CITY OF ALBUQUERQUE

September 22, 2017

RE: **2100 Osuna NE**
Grading Plan Engineer's Stamp Date 8/1/17
Drainage Report Engineer's Stamp Date: 9/1/17
Drainage File: E16D001

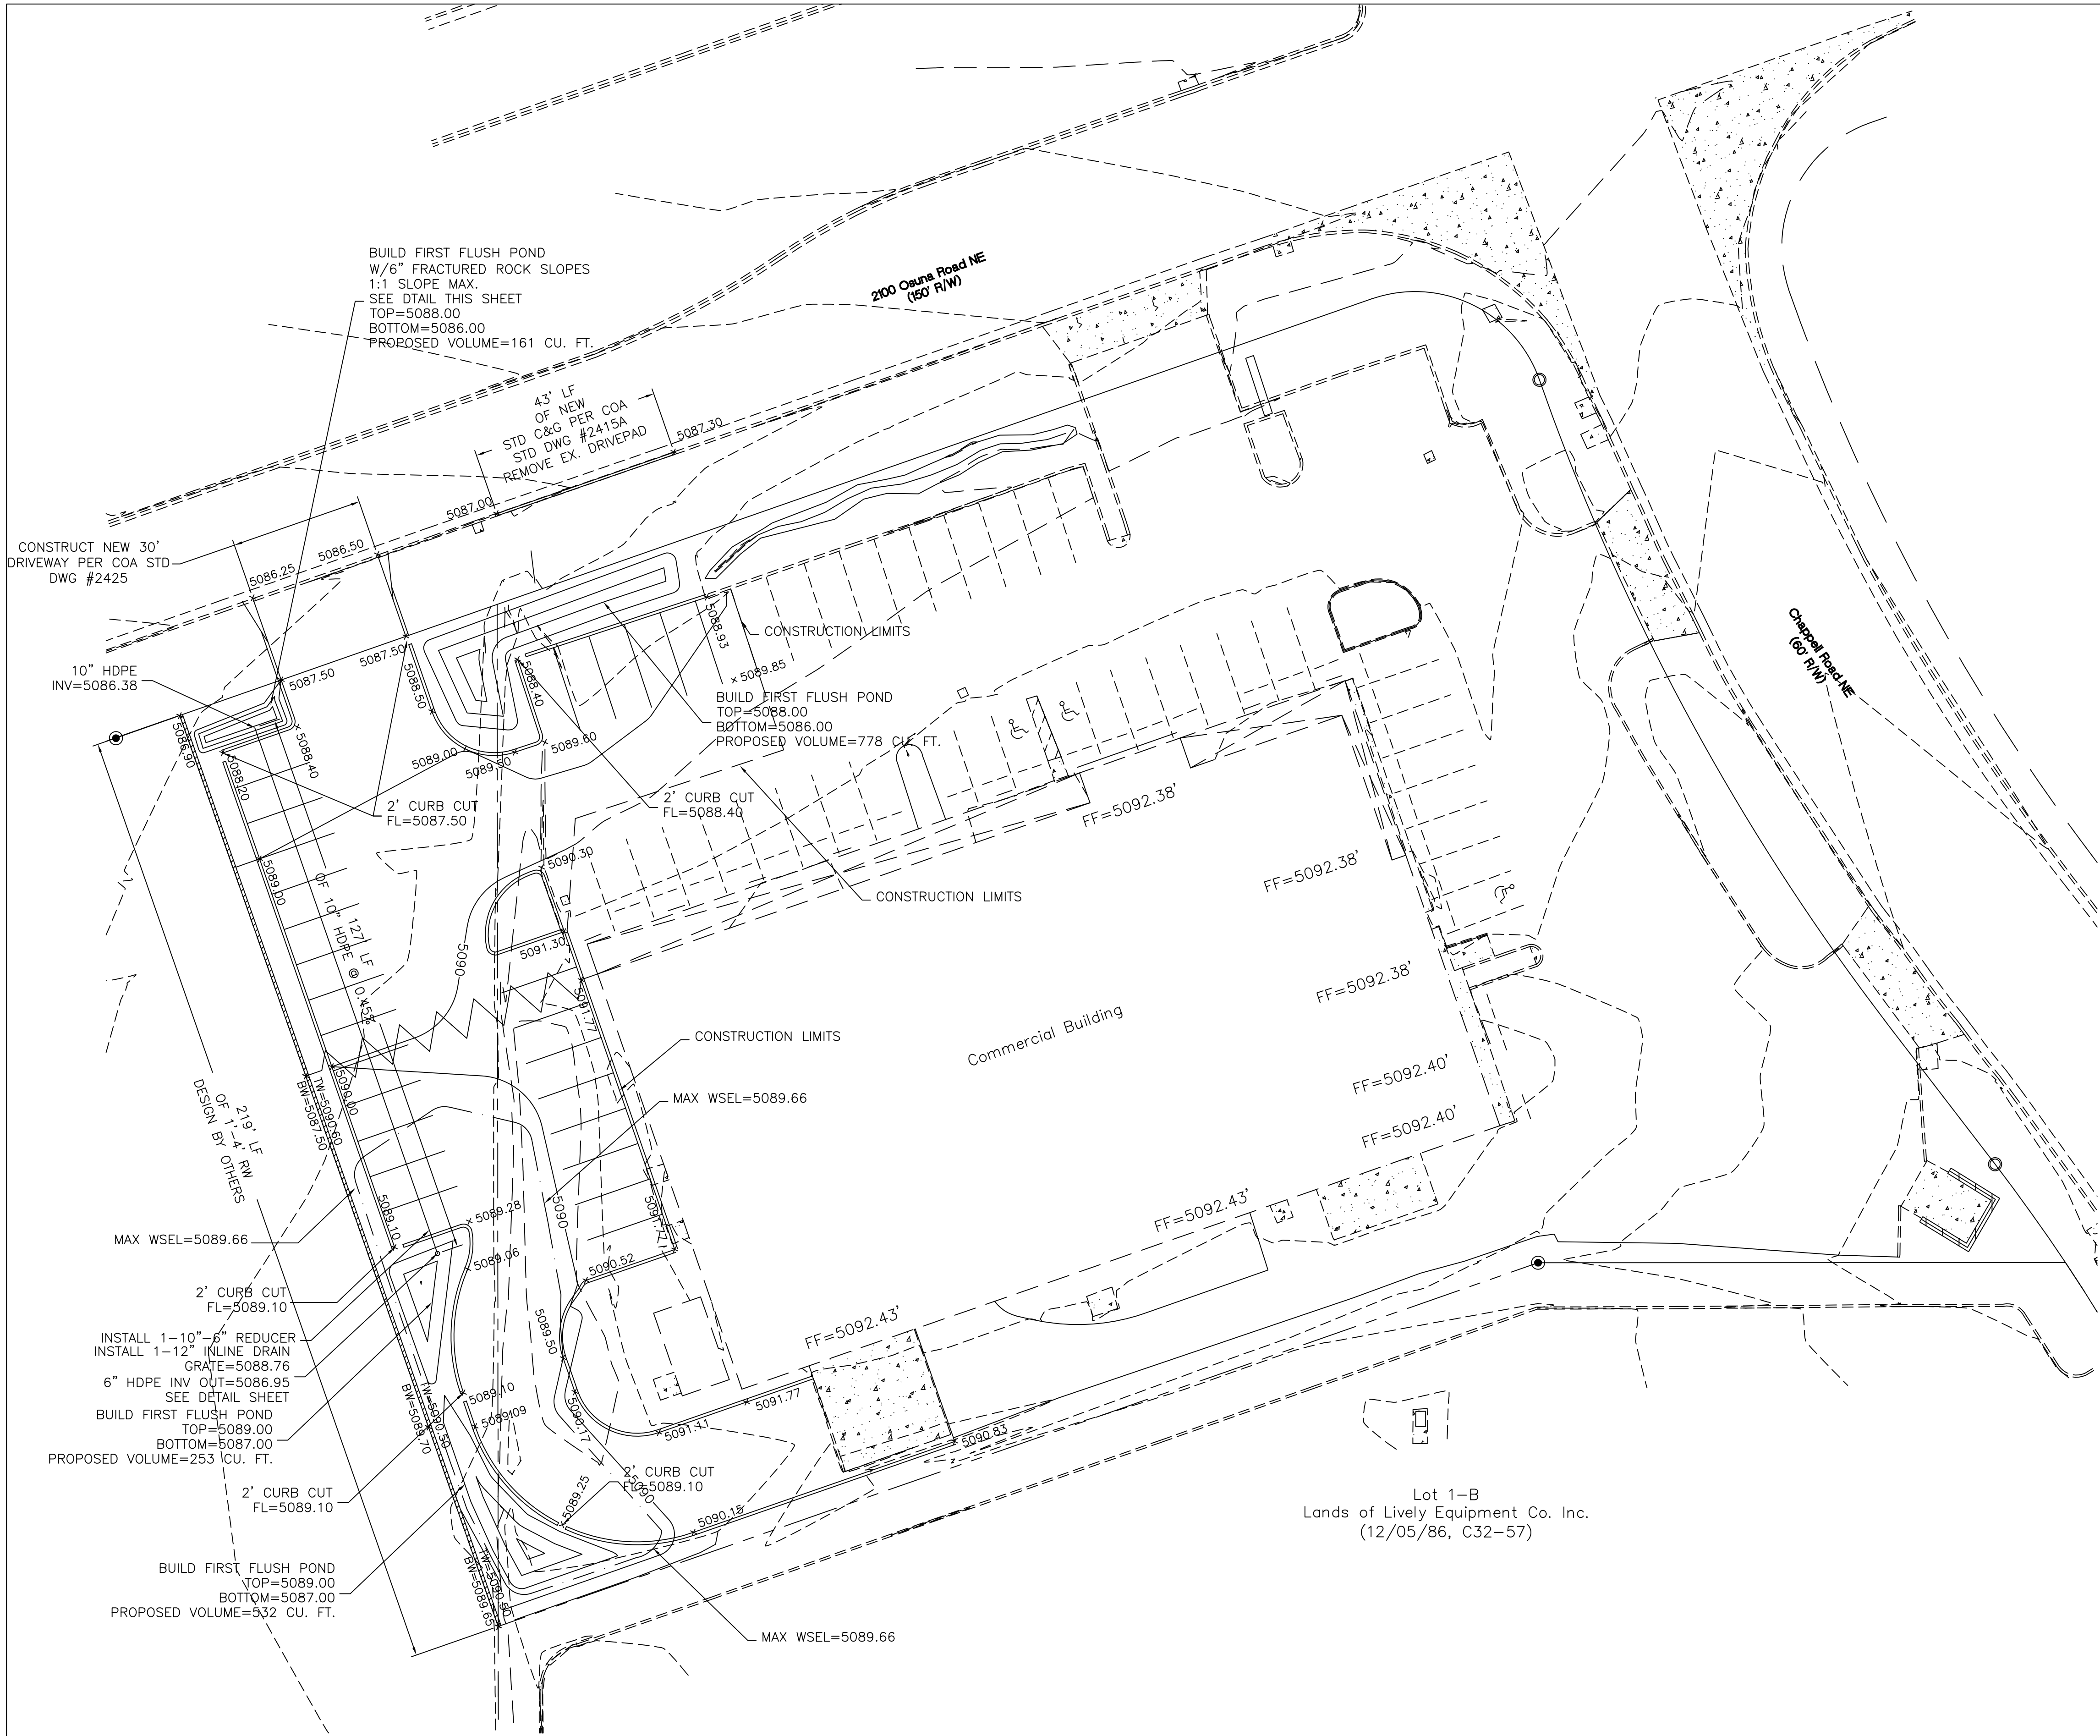
1. How does Lot 1B (to the south of this site) drain? It appears to drain to its NE corner and onto the SW corner of your site. Provide additional discussion regarding this. If there are off-site flows, these will need to be routed across your site as well.
2. The Stormwater Studio appendix does not match the grading plan with respect to slopes and inverts of the drain pipe.

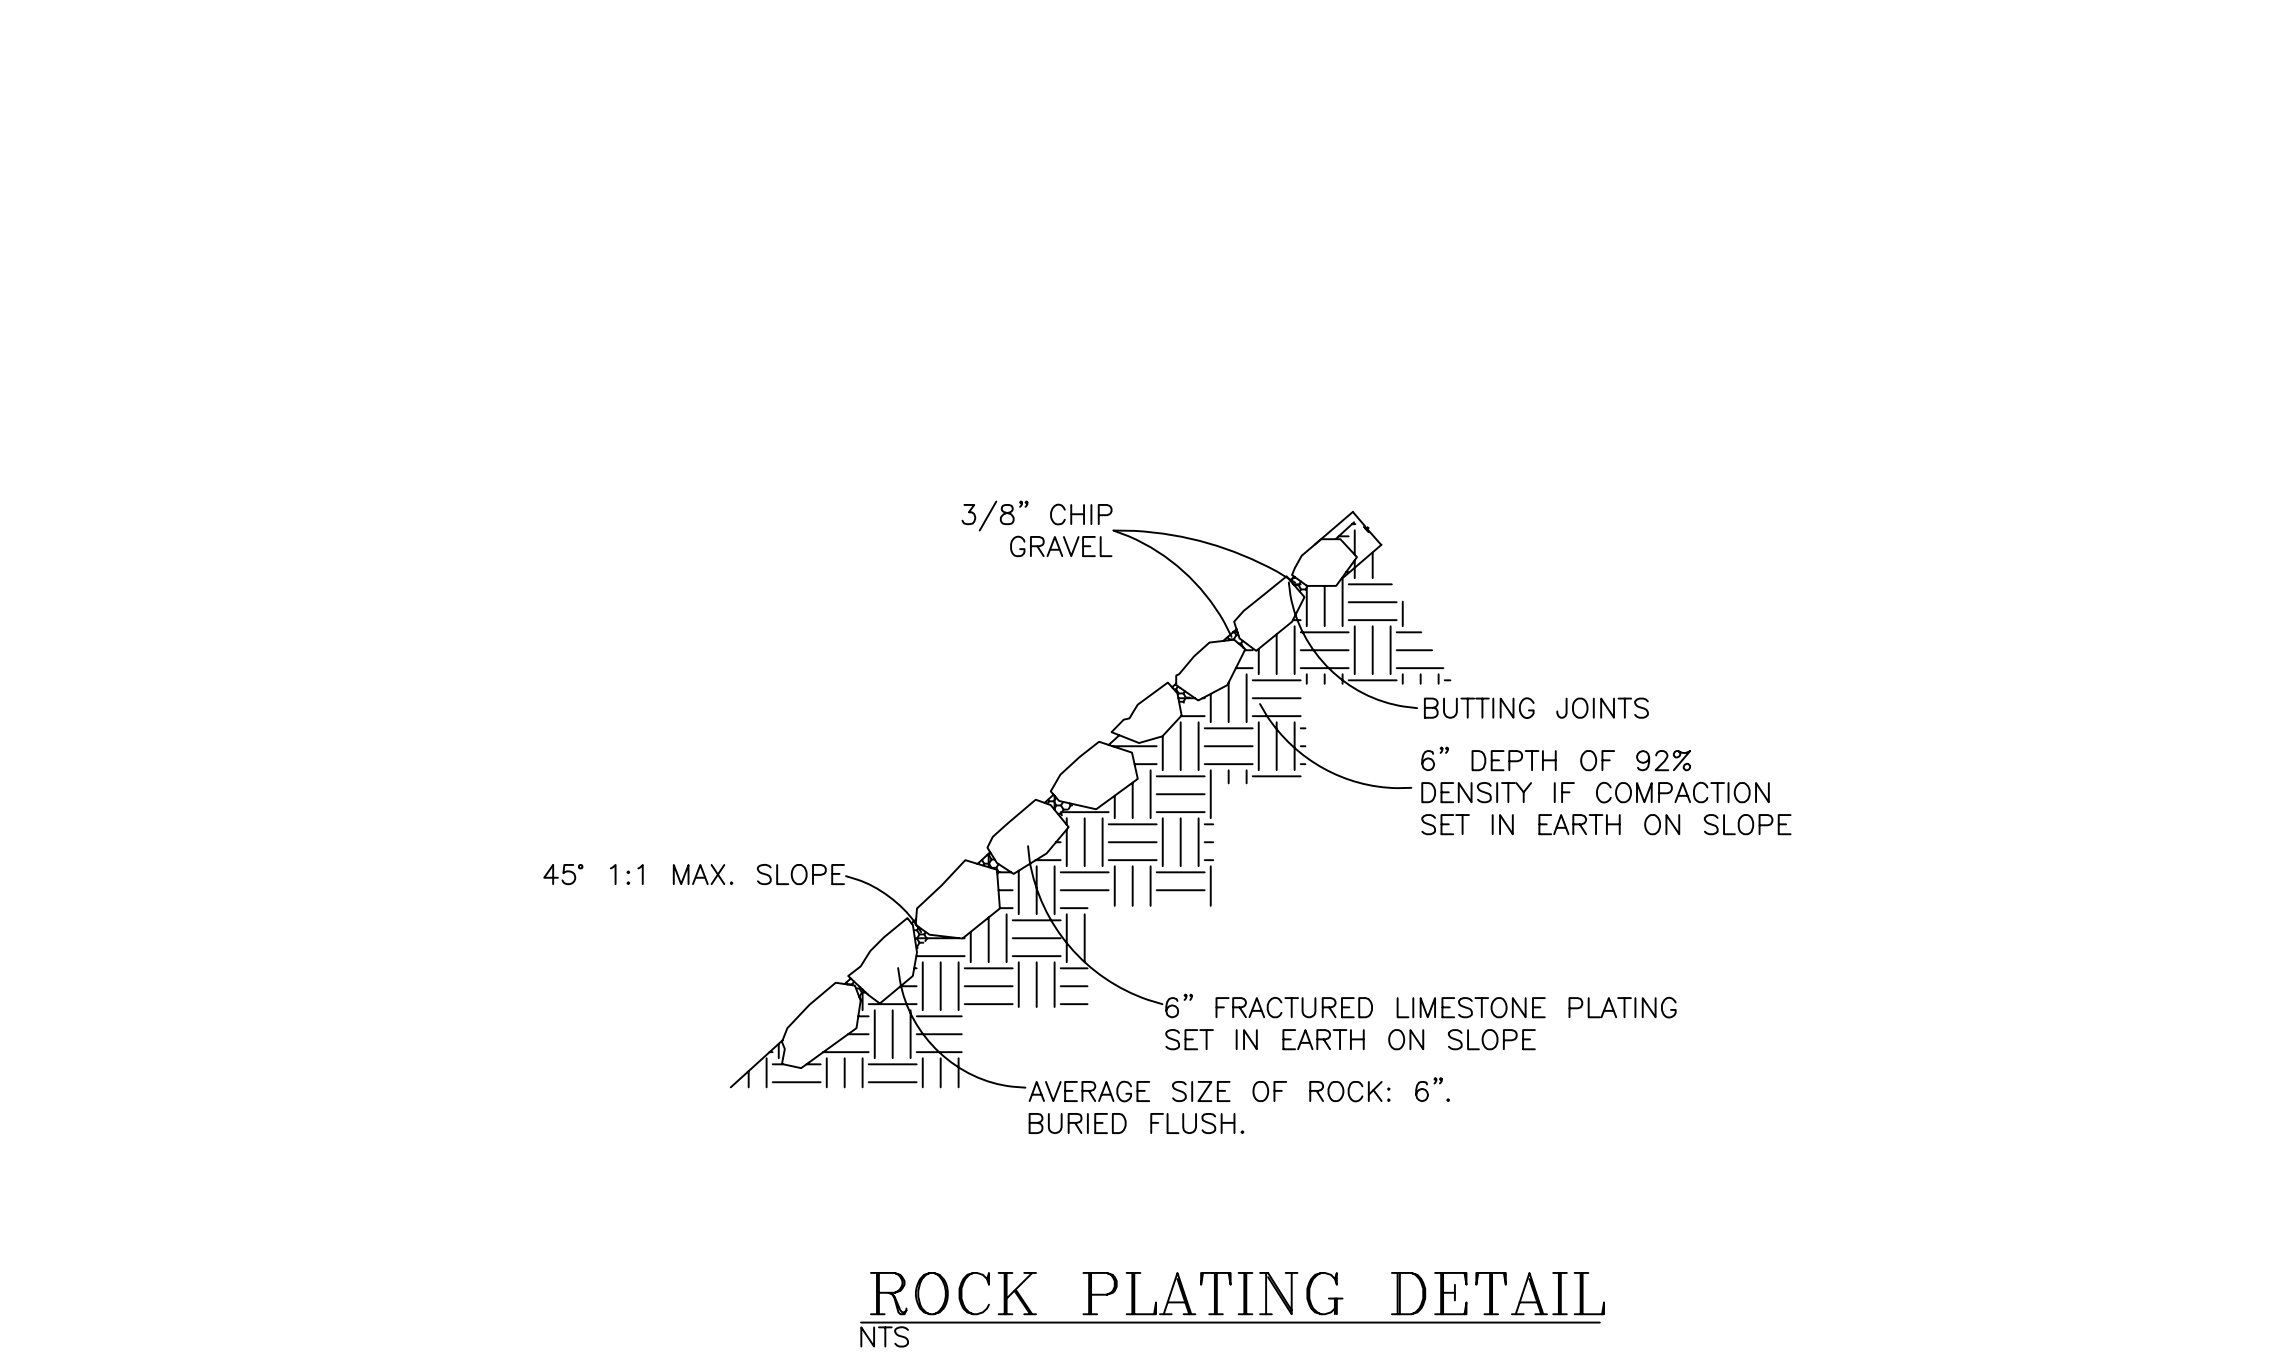
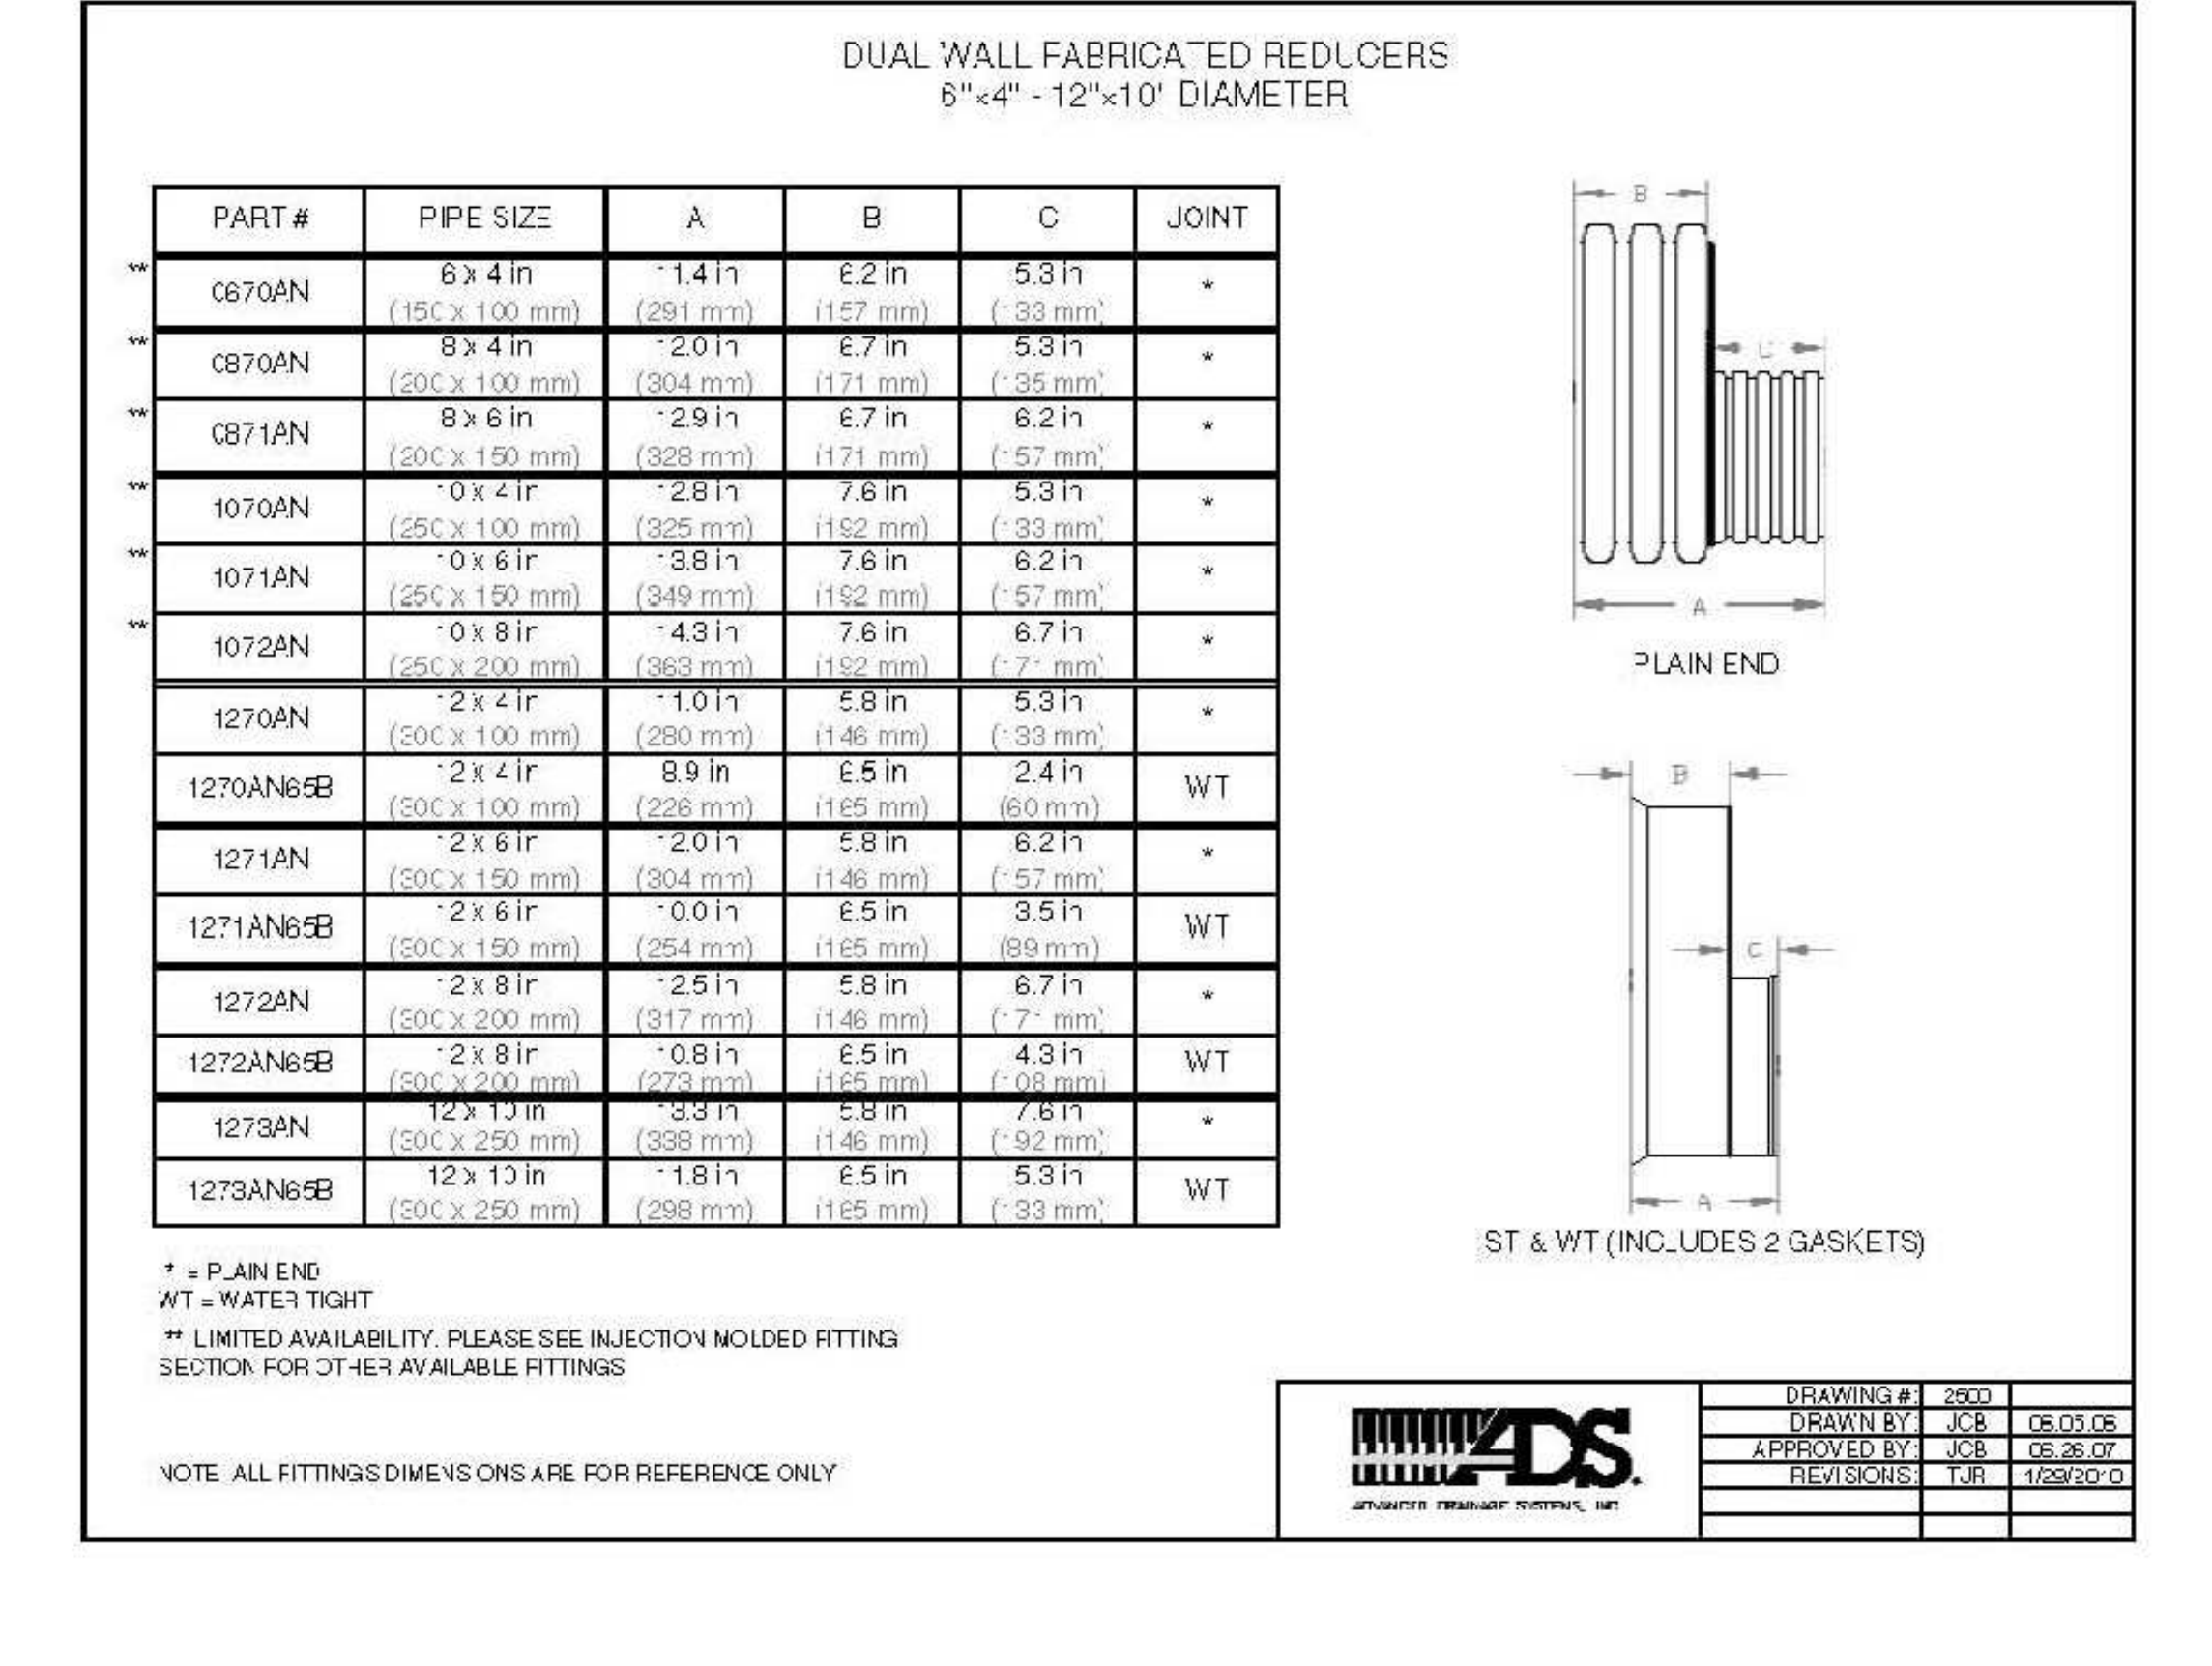
1. Laying the storm drain pipe at a 0.35% slope does not seem constructible; a slope closer to 1% is recommended.
2. Provide a detail for the outlet/reducer/drain grate at the SW pond.
3. Modify the linetype for the existing contours so they stand out from the proposed contours. Add contour labeling to both.
4. Extending existing topo south and west of the SW pond. It is unclear what flows may be entering/existing at this corner.
5. Clearly define the overland flow-path (emergency overflow) from the SW pond to Osuna. Include elevations, dimensions and erosion protection.
6. Provide a section view through the retaining wall.
7. An additional curb cut and grade break at the new entrance appear necessary at the small NW pond to route flows into the pond from the parking lot:
